[REDACTED]
Infrastructure Manager
Lincolnshire County Council
County Offices
Newland
Lincoln LN1 1YL

Date: 16 July 2026

Application by Beacon Fen Energy Park Limited for an Order granting Development Consent for the Beacon Fen Energy Park Project

Figure 1.4 Indicative Site Layout Plan
Document Reference: 6.4 ES Volume 3, 6.4.4
April 2025

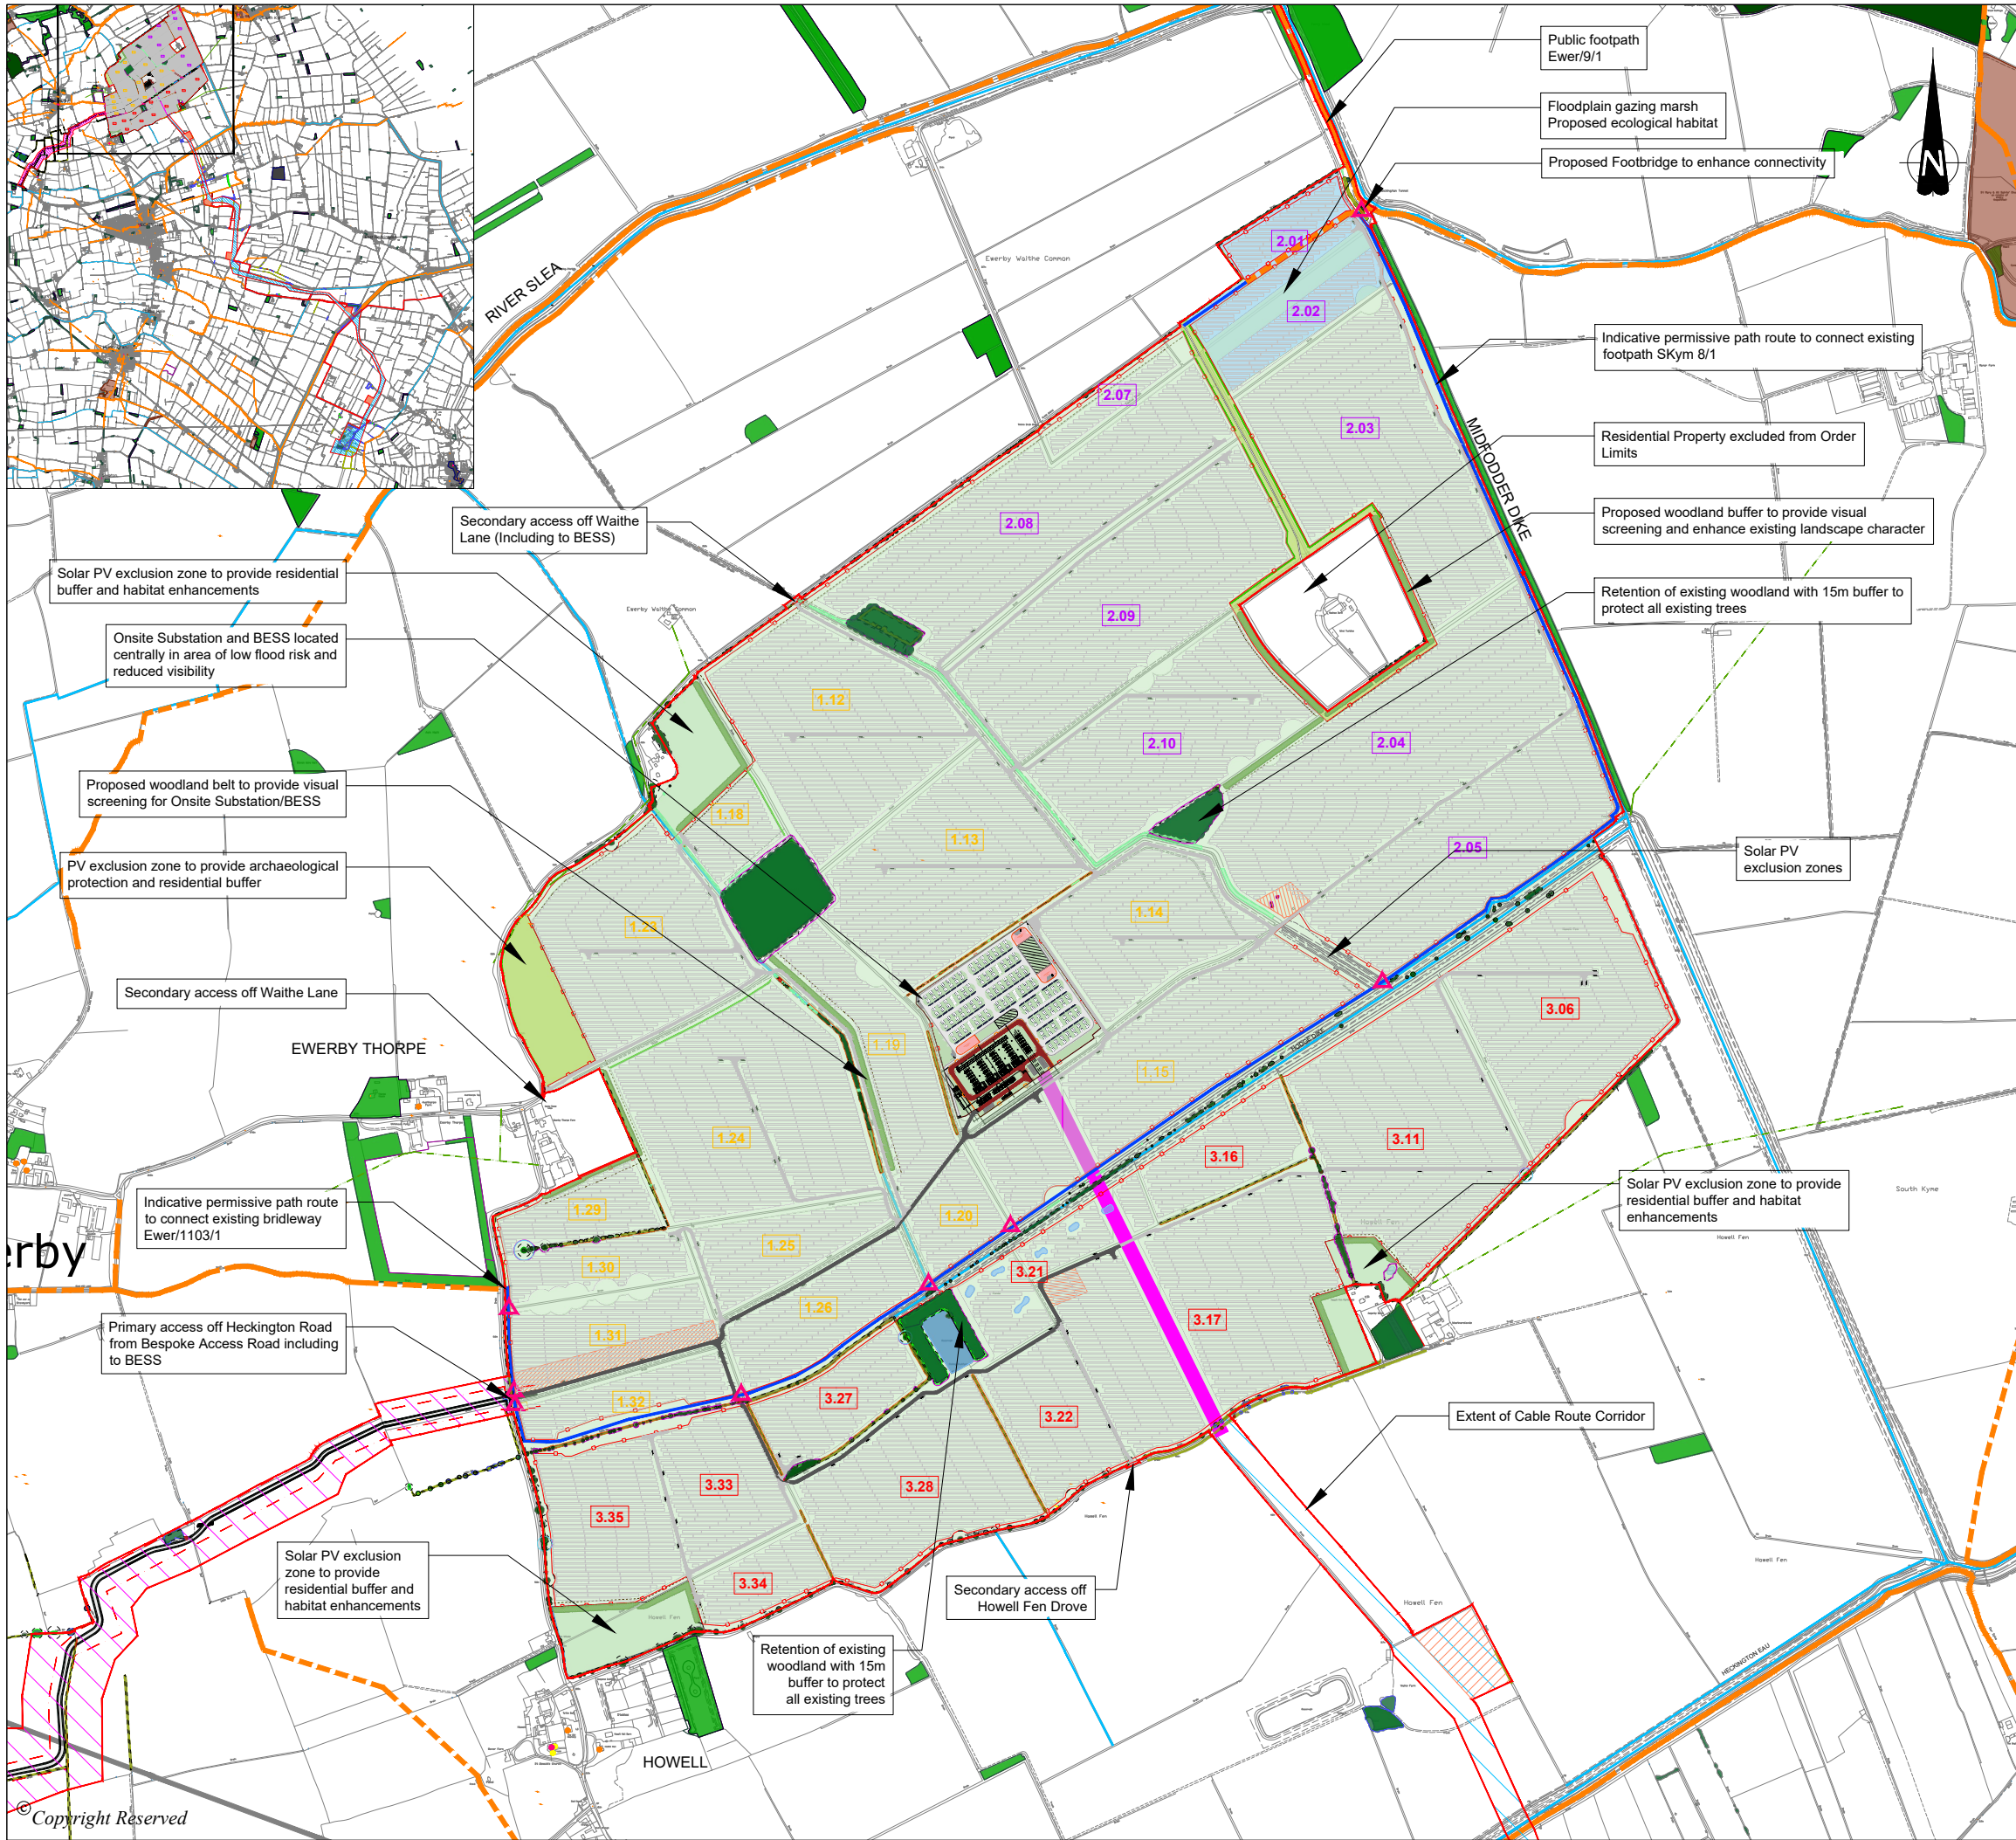
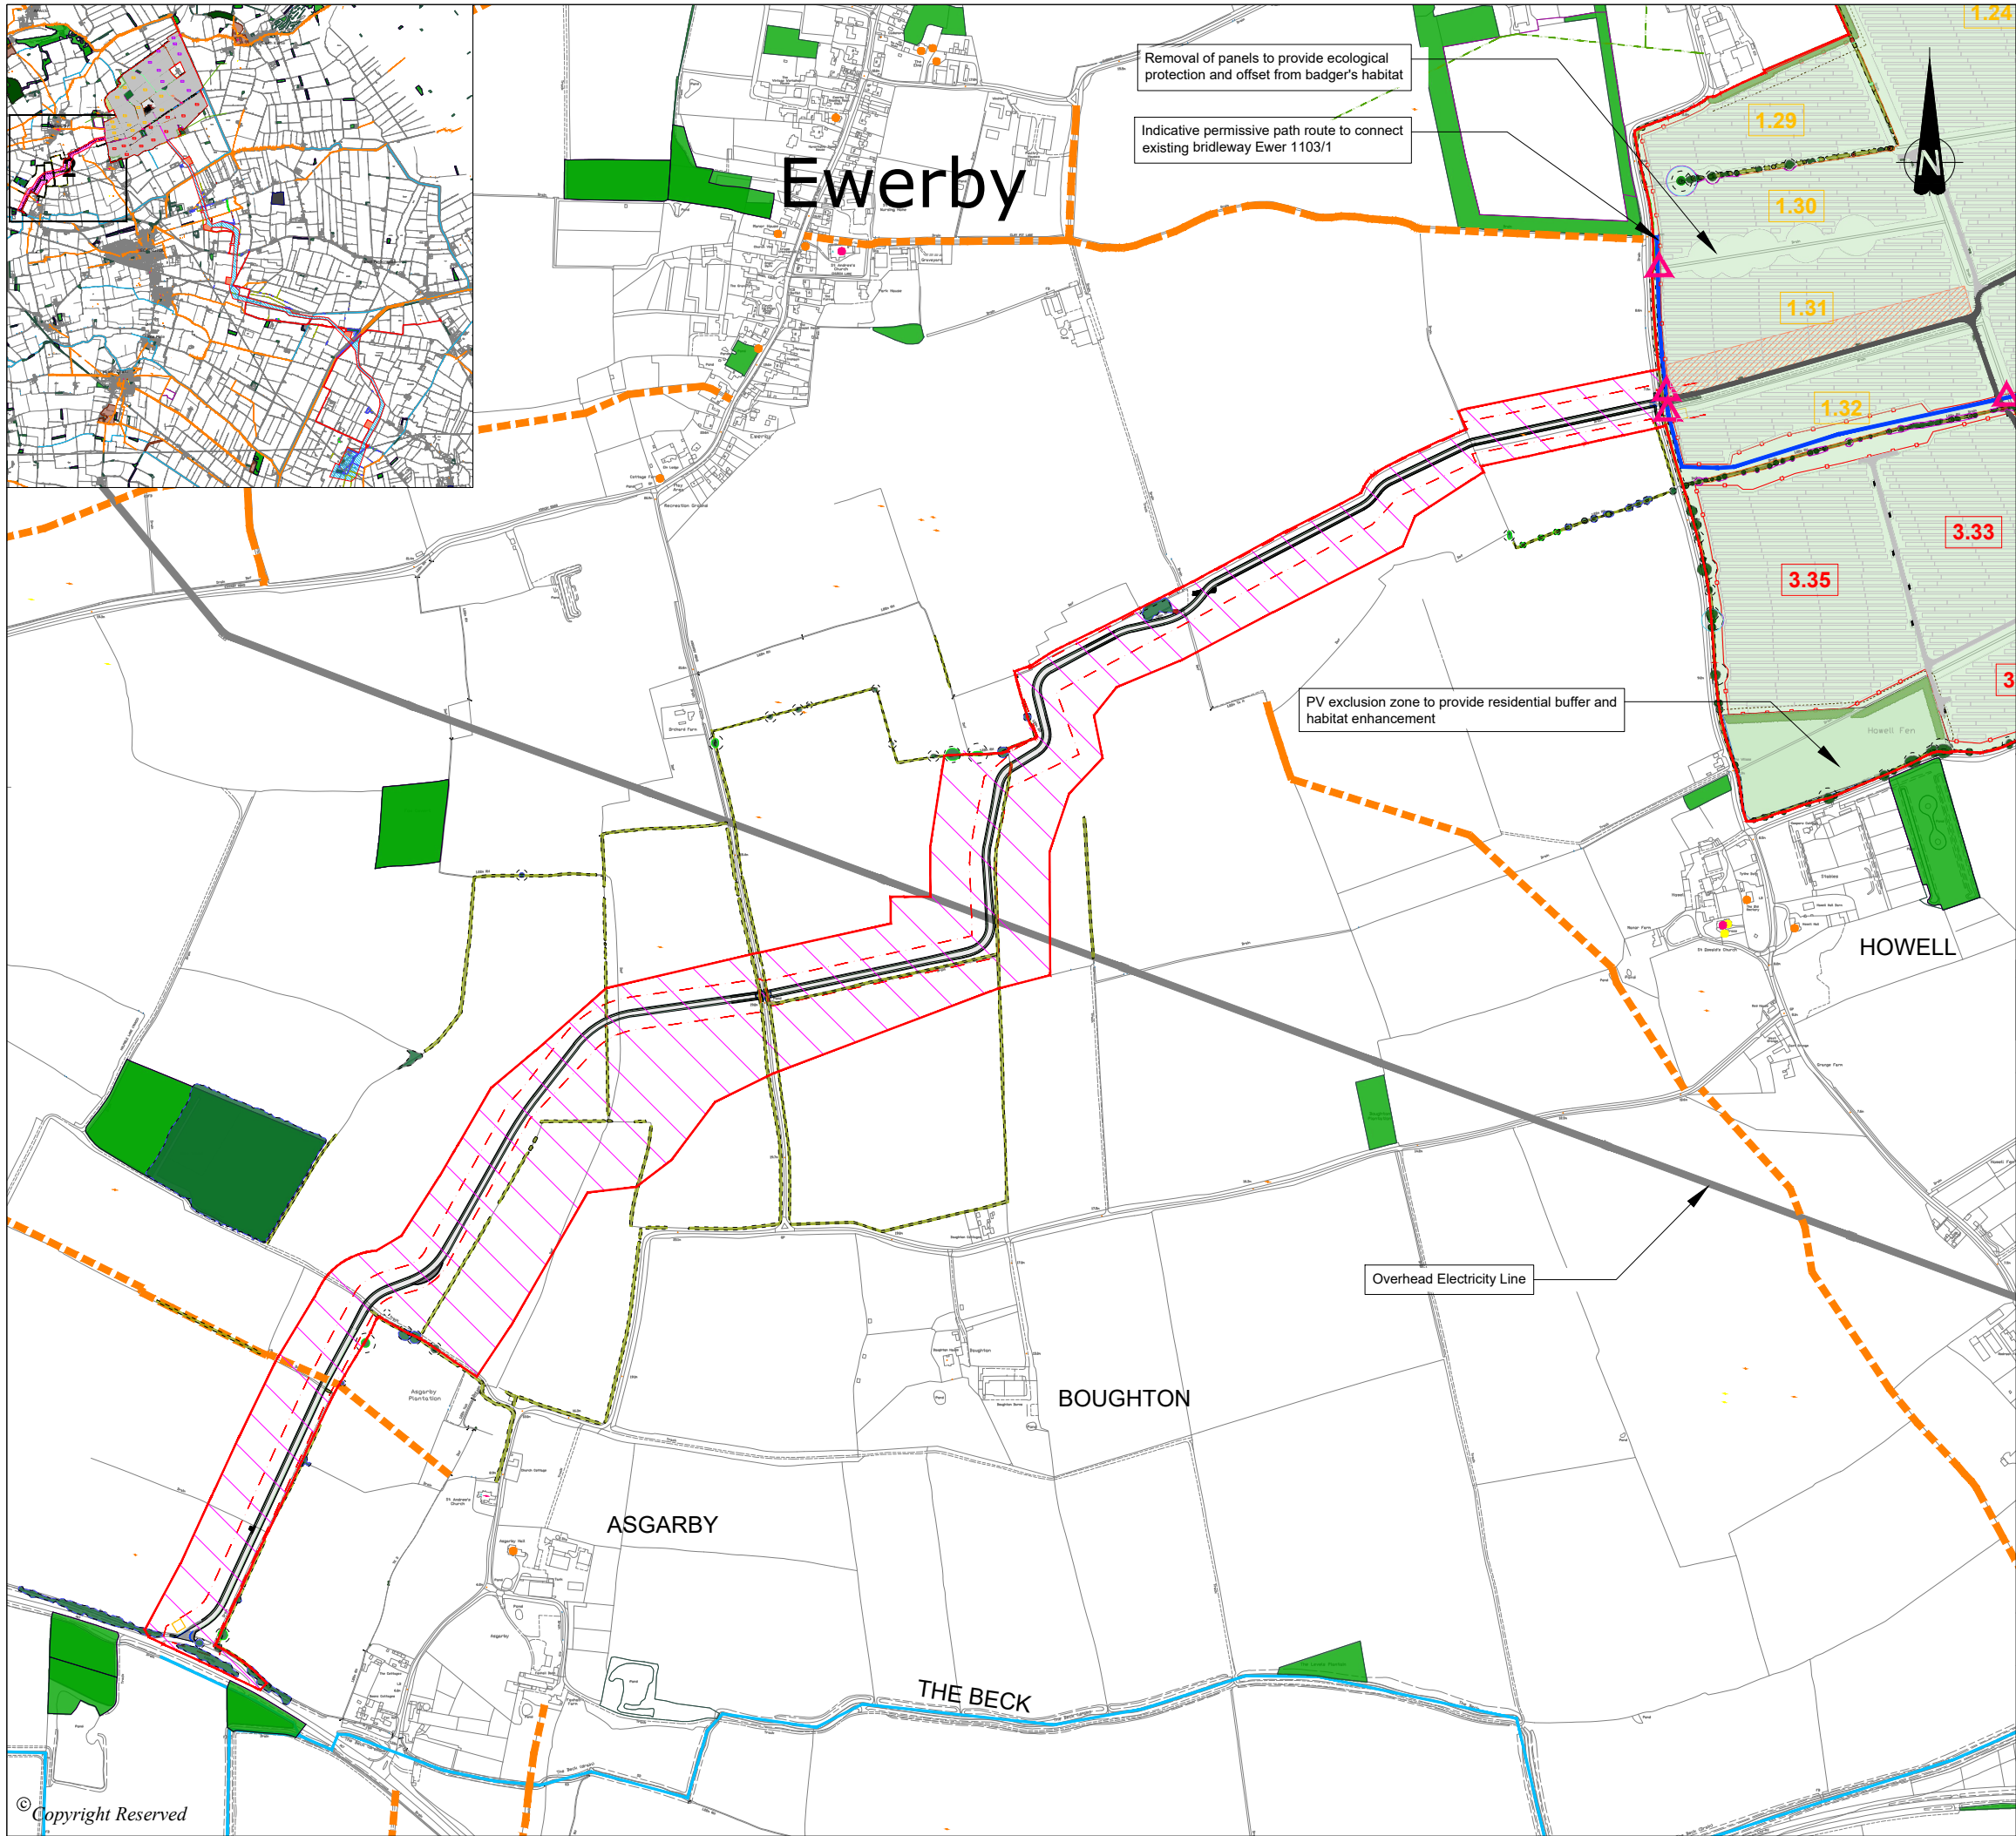
The Council notes the Applicant's responses to questions on mitigation for skylark and bats. In relation to mitigation provided for skylark, the Applicant has stated that PV exclusion zones areas identified in 6.4.4 Figure 1.4 Indicative Site Layout Plan (Revision 1) [REP2-028] *"...will be managed to support a greater density of skylark than at present..."*. The Council also notes the Applicant's updates to the Outline Landscape and Ecological Management Plan which state that *"Within the open buffer areas adjacent to ditches and in the wildflower meadows the habitats will be improved for ground nesting birds, including skylark,..."*. Whilst the Council welcomes these commitments and recognises the potential value of these areas for foraging birds, the exclusion zones identified in REP2-028 and buffer areas adjacent to ditches are considered unlikely to be of sufficient scale or openness to accommodate skylark's ecological requirements for extensive open habitat and unobstructed sightlines in order to successfully nest. The latest research strongly suggests that skylark actively avoid panel arrays for breeding purposes, along with any boundary feature >3m, using these grassland areas instead for foraging. The extent of this avoidance behaviour is 50-85m from boundary features >3m meaning the vast majority of the development site will become unsuitable for breeding skylark."

With the above in mind, the Council maintains its position stated during the examination that there is insufficient mitigation provision for ground nesting farmland birds, in particular skylark. ES Chapter 7 Ecology (Revision 4)[REP8-013] predicts a “permanent very low adverse impact” on skylark (REP8-013, 7.6.61). The Council therefore remains concerned about the potential for cumulative impacts on ground nesting bird species, particularly skylark, arising from the number of similar developments across the County.
